**United Utilities Water Limited
Planning, Landscape and Ecology**
1st Floor, Thirlmere House
Lingley Mere Business Park
Lingley Green Avenue
Warrington
WA5 3LP

Your ref: 3/2019/0999
Our ref: DC/19/4792
Date: 09-OCT-20

Location: Land off Henthorn Road, Clitheroe, BB7 3BY

Proposal: Erection of up to 160 dwellings with public open space, landscaping and sustainable drainage

drawing number
9053-L-02

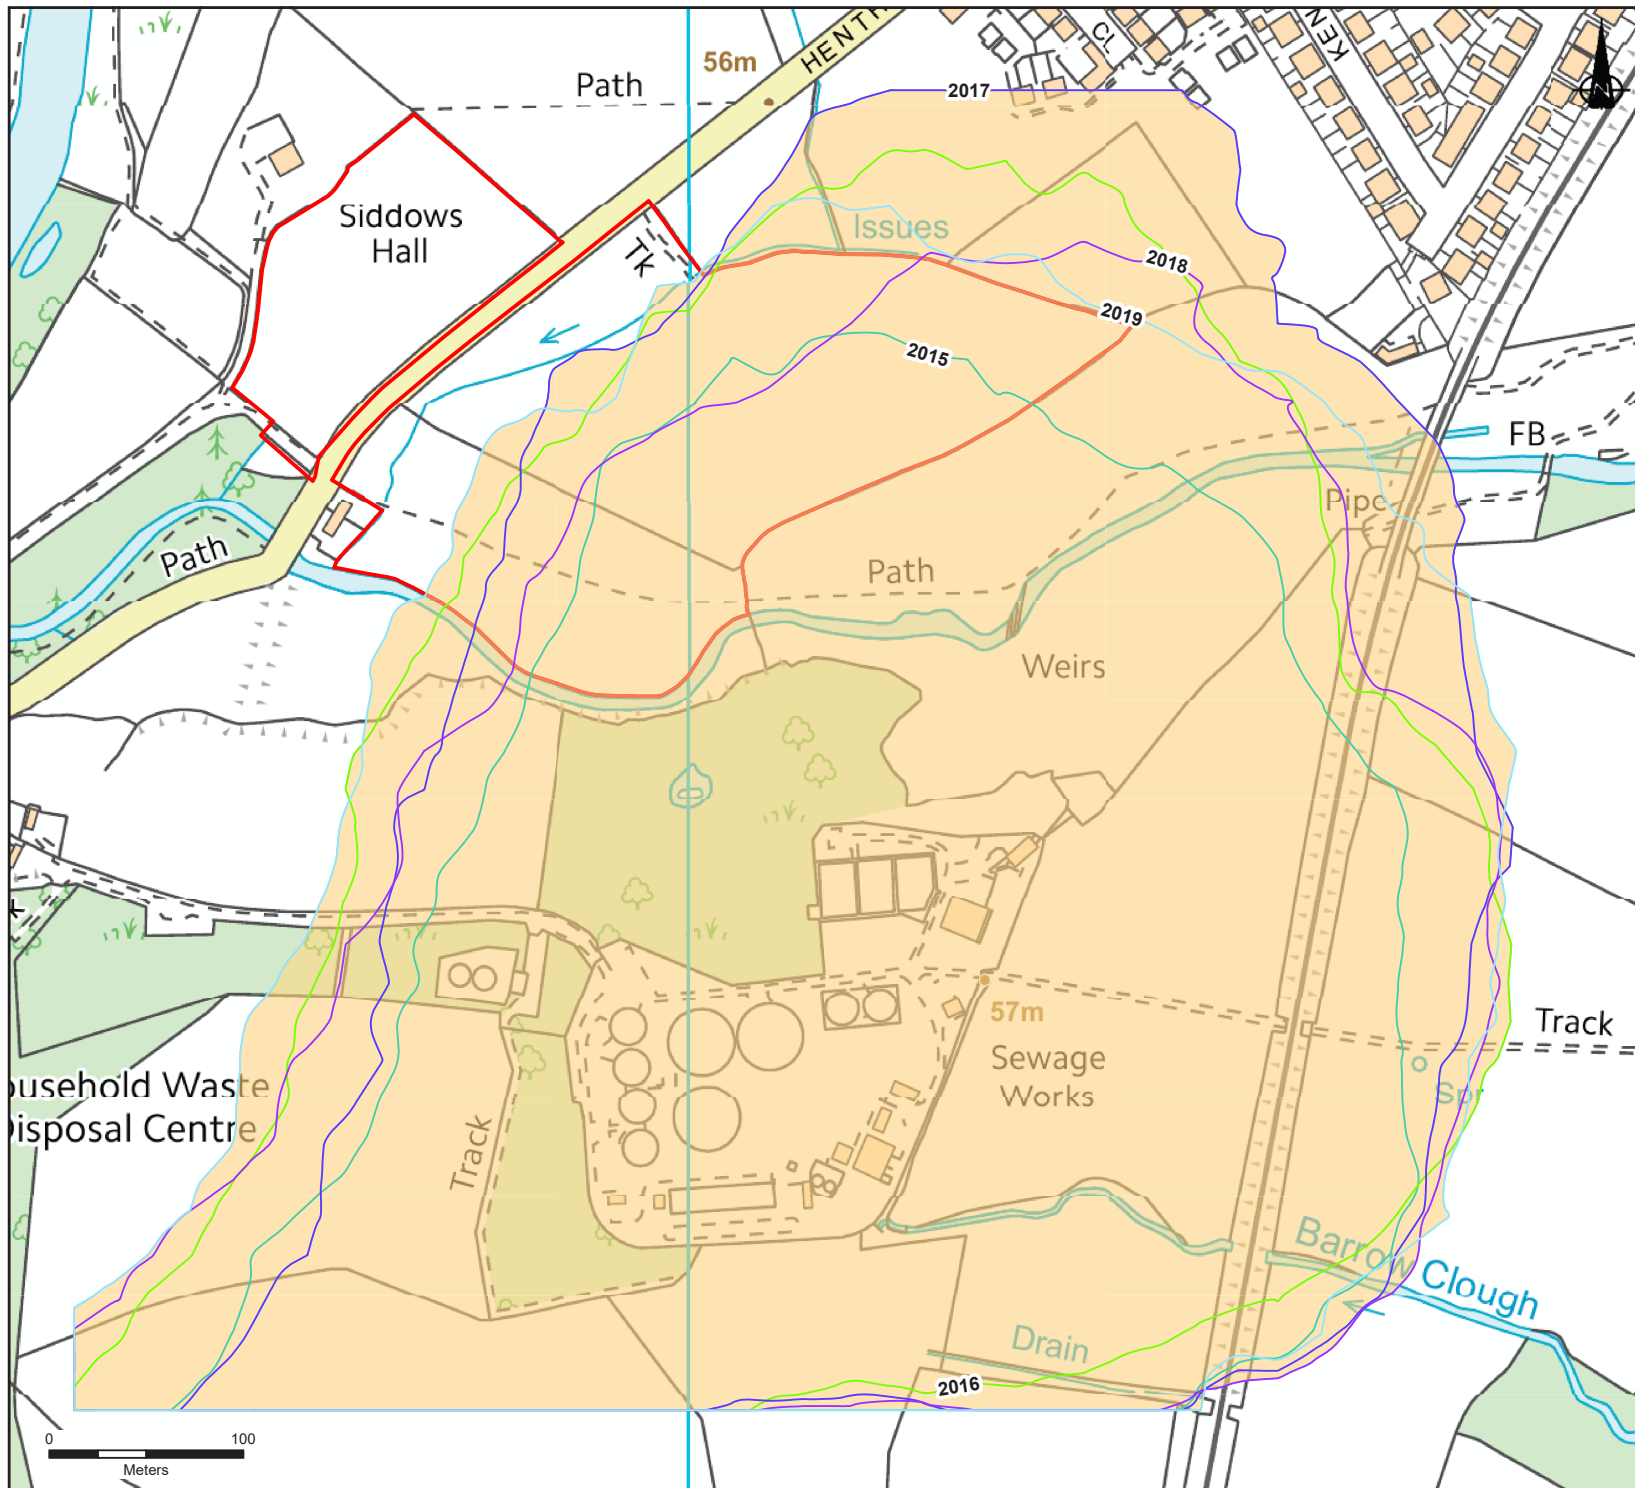
The Design & Access statement rev B [DaS] explains that a Development Framework Plan sets the parameters of the proposed development. This plan is shown at Figure 13 of the DaS. This plan proposes that development (i.e. residential dwellings) could be located around 15m north of the existing Public Right of Way no. 3-1-FP 17. This is around 155m north (as the crow flies) from the Clitheroe WwTW. It is this plan that United Utilities have used to assess the potential effects of the proposed development, and has likewise formed the basis of the applicant's assessment in their OIA.

The modelling shows that the risk of unacceptable odour conditions on the part of the site west of Henthorn Road is low and United Utilities would generally consider that housing would be an acceptable use in this location. However, on the remaining part of the site to the east of Henthorn Road, odour concentrations are predicted to be above $3 \text{ ou}_E/\text{m}^3$ on parts of the site and occasionally above $6 \text{ ou}_E/\text{m}^3$. United Utilities consider that these areas would be unacceptable for residential use.

- a Removing the residential development proposed in the 3 ou_E/m³ contour in all assessment years as identified in the OIA; or,
- b Remove the source of the odour.
